**TAFE NSW WESTERN SYDNEY CONSTRUCTION HUB**

**BUILDING CODE OF AUSTRALIA 2019 Amendment 1  
SCHEMATIC DESIGN REVIEW**

**JANUARY 2021**

Report prepared for	Gray Puksand 1/156 Clarence Street Sydney NSW 2000  Attention: Barry Hackett
Report prepared by	Metro Building Consultancy Suite 102, 12 Mount Street, North Sydney NSW 2060  Consultant: Sean Moore
Report reference	20243R03 BCA
Job number	20243
Date	22 <sup>nd</sup> January 2021

LOWER GROUND - GA FLOOR
PLAN

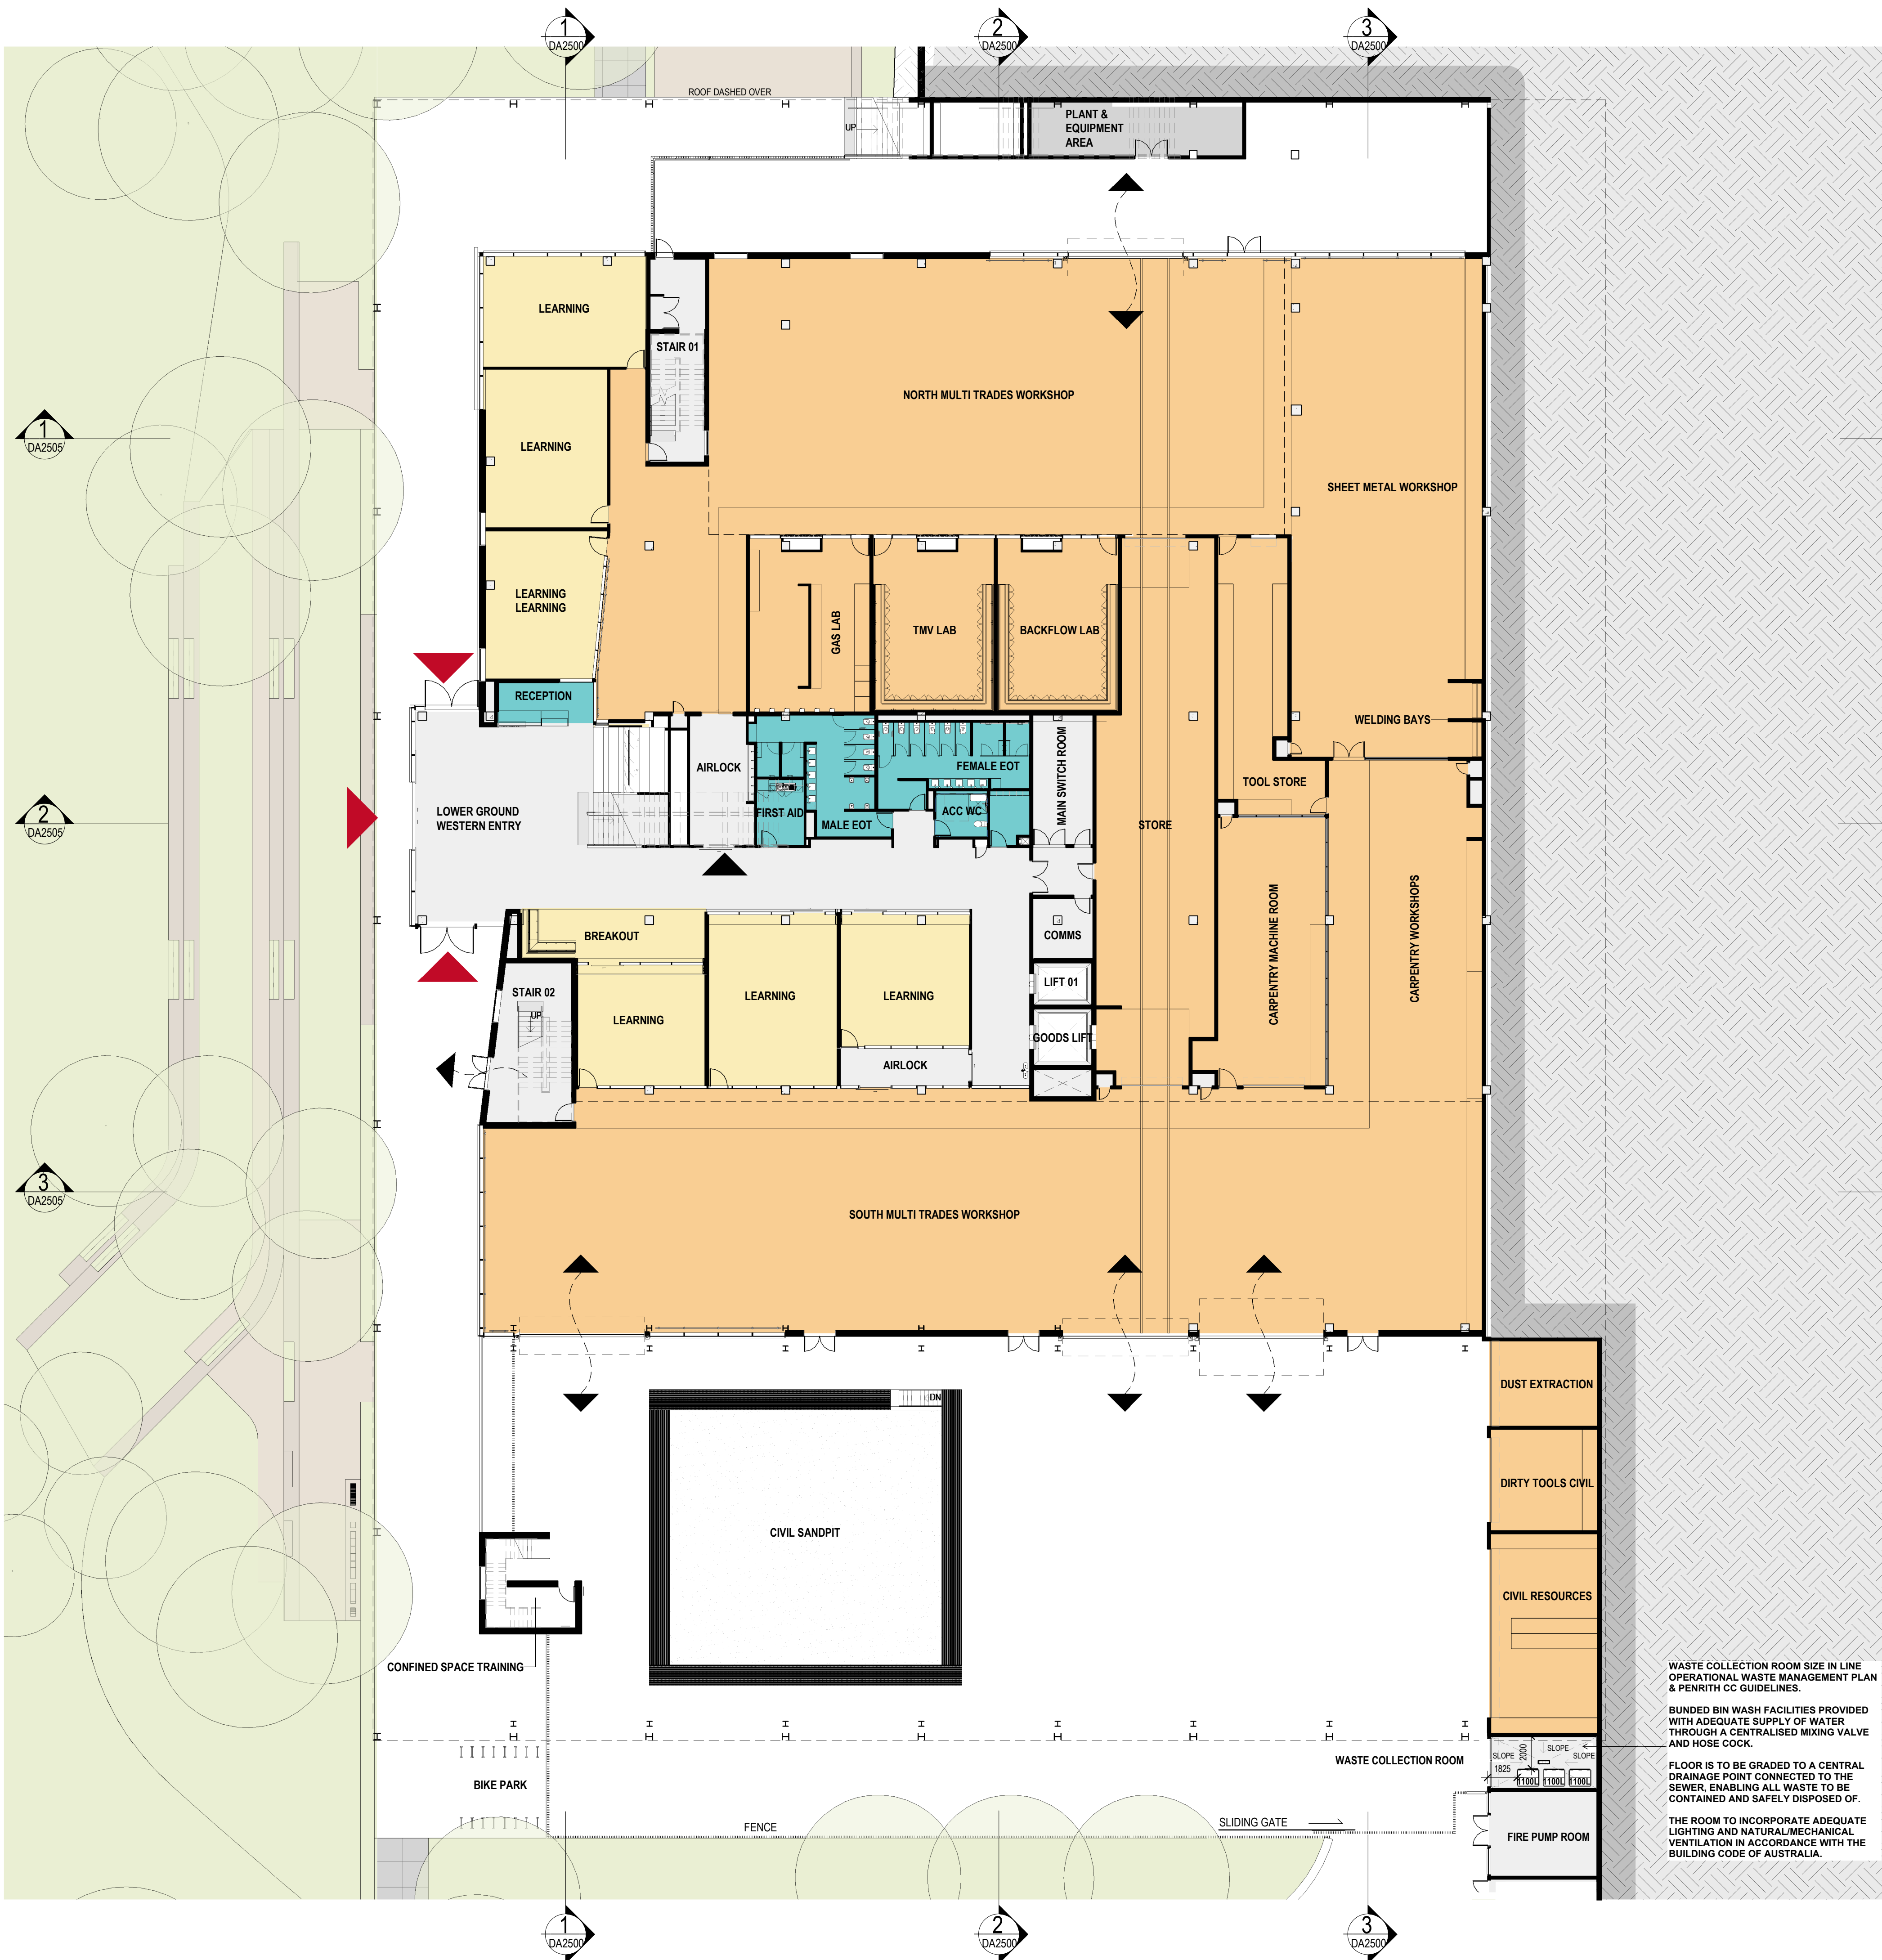
Note that the Class 7b occupies more than 10% of the floor area of the lower ground storage and is required to comply with the FRL's specified for Class 7b construction as listed in Specification C1.1 Table 3. Note the higher FRLs required for Class 7b usage in the table in Appendix B of this report.

Client to confirm if the storage rooms allocated will be utilised for the storage of all materials or if there will be areas within the workshop areas used to store workshop materials.

- Single height workshop – distance to a point of choice 30m in lieu of 20m, travel to an exit 77m in lieu of 40m and distance between exits 98m in lieu of 60
- Please confirm how egress is to be achieved from the external workshop storage areas (i.e. show the doors providing access)

LEVEL 1 - GA FLOOR PLAN

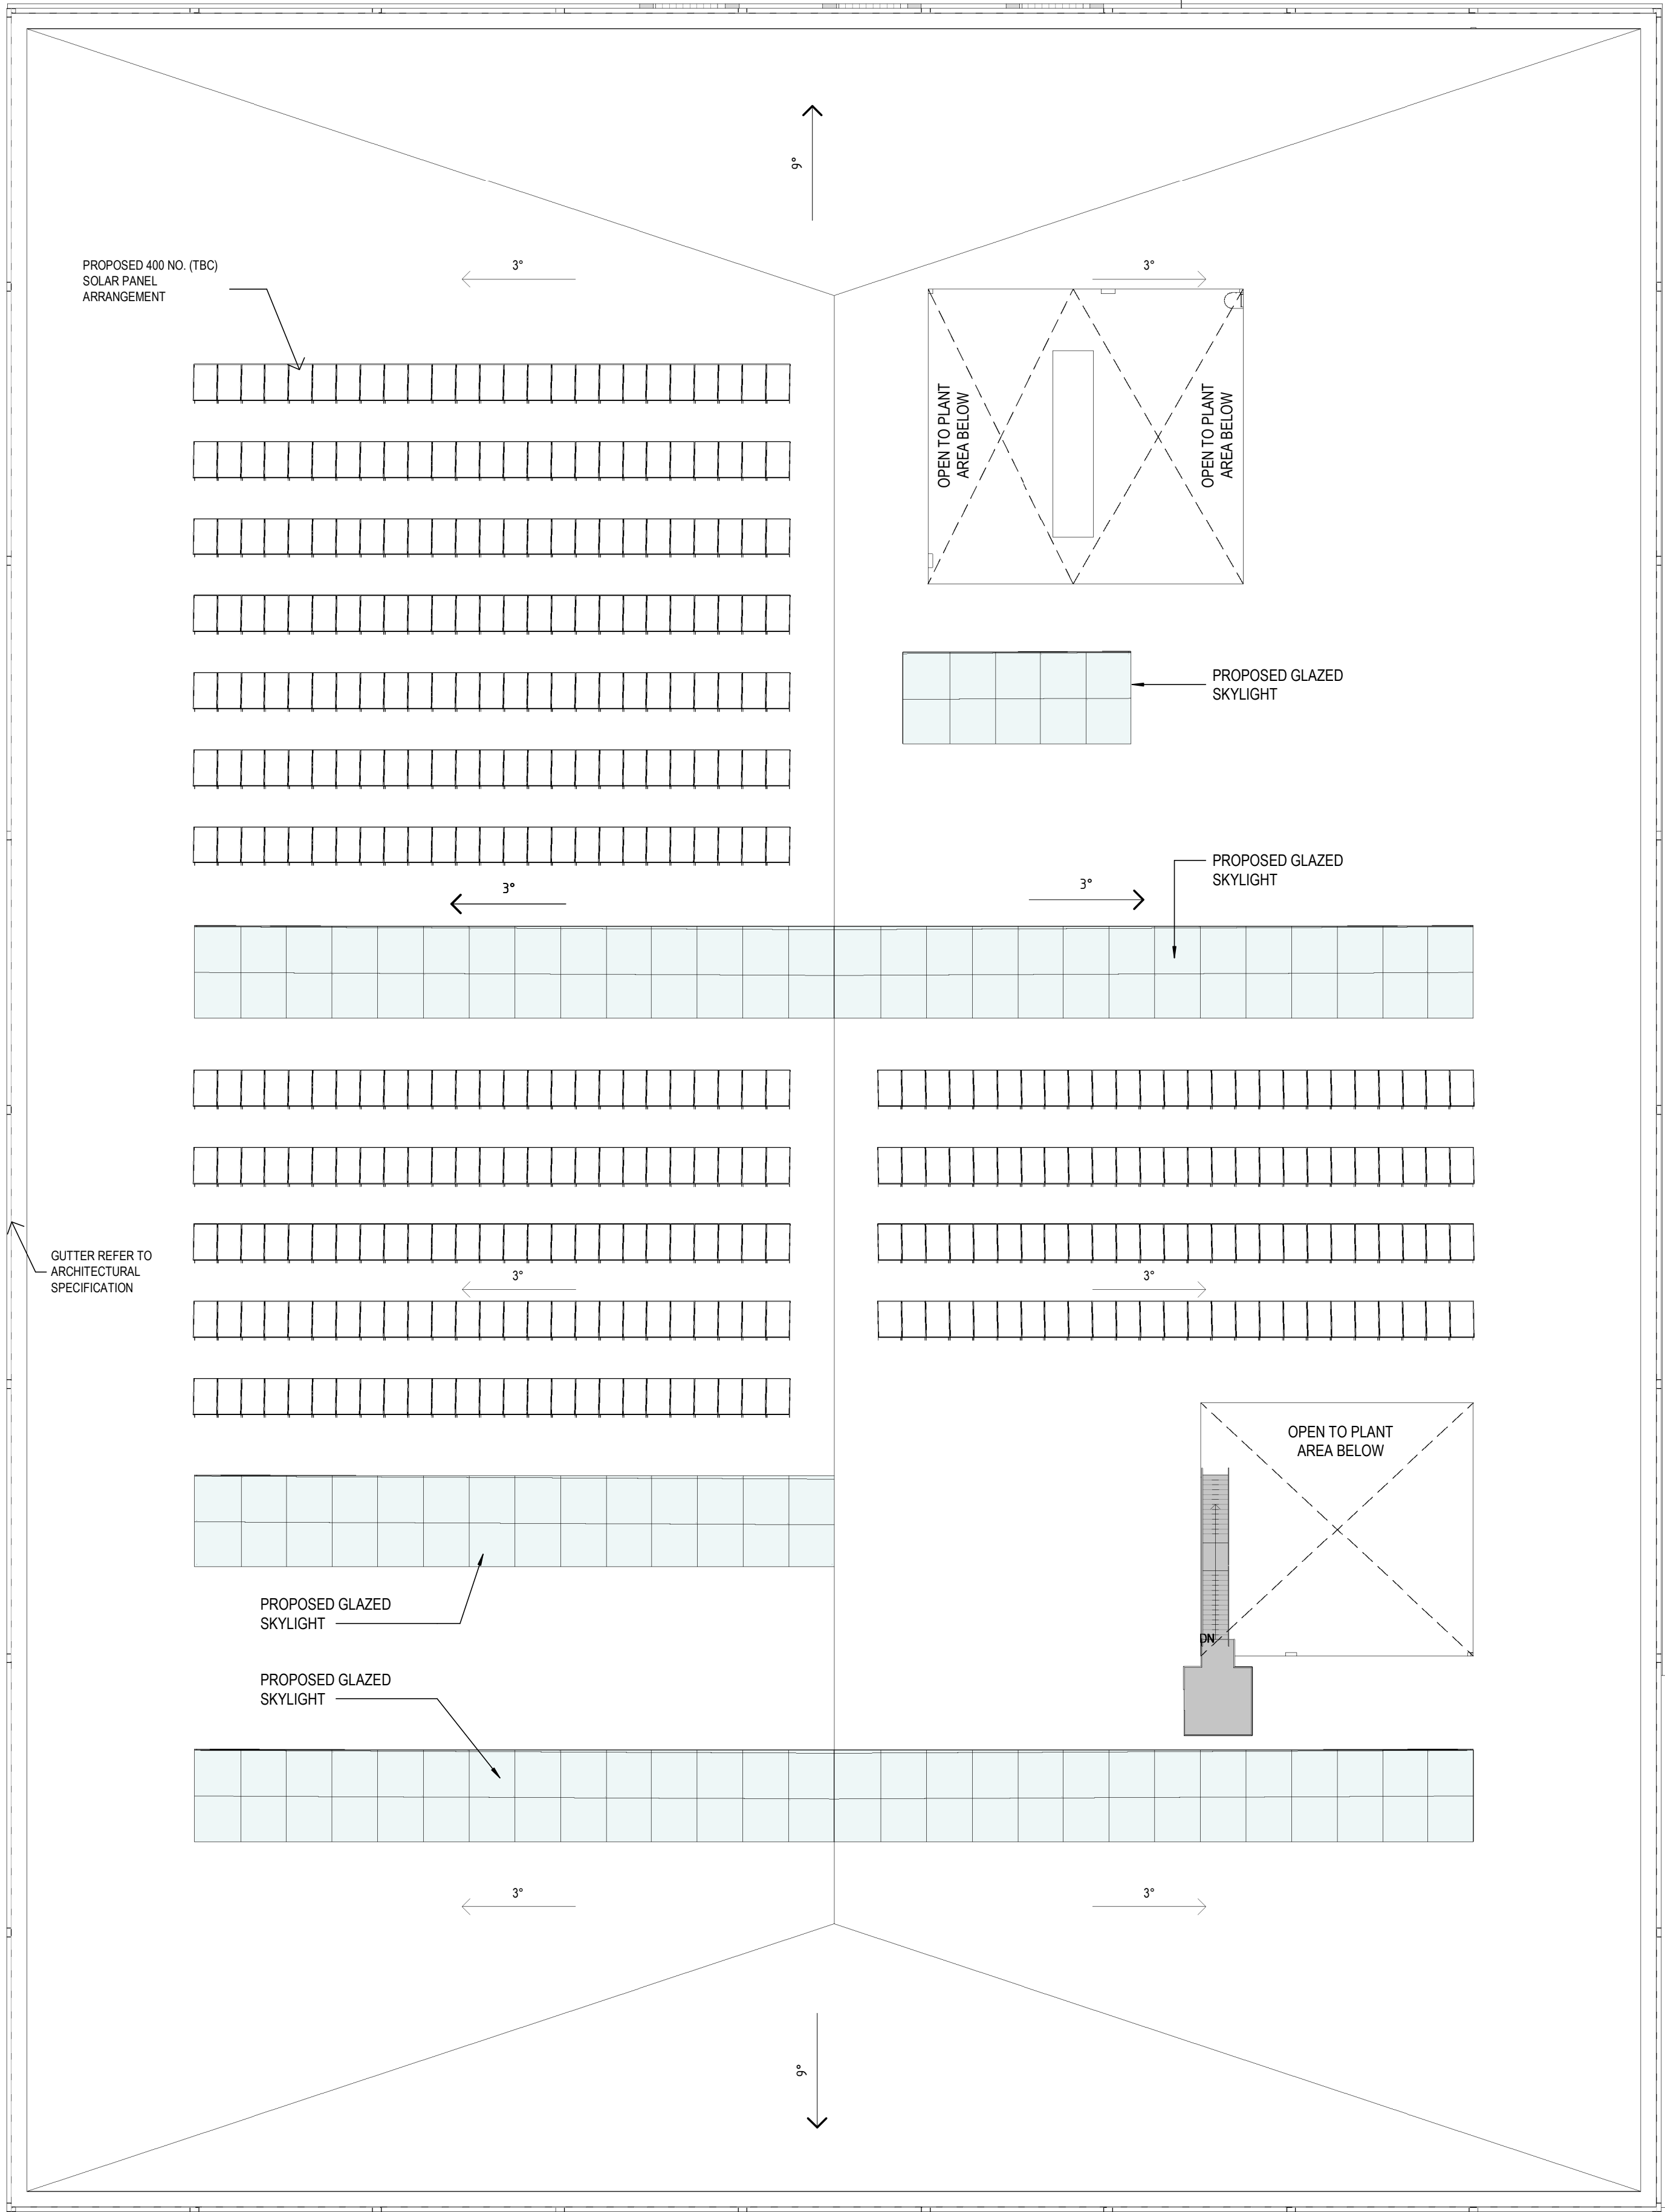
- Roof terrace and office workspace – distance to a point of choice exceeds 20m, distance between exits approx.. 80m in lieu of 60m
- Auditorium – distance to a point of choice 29m in lieu of 20m
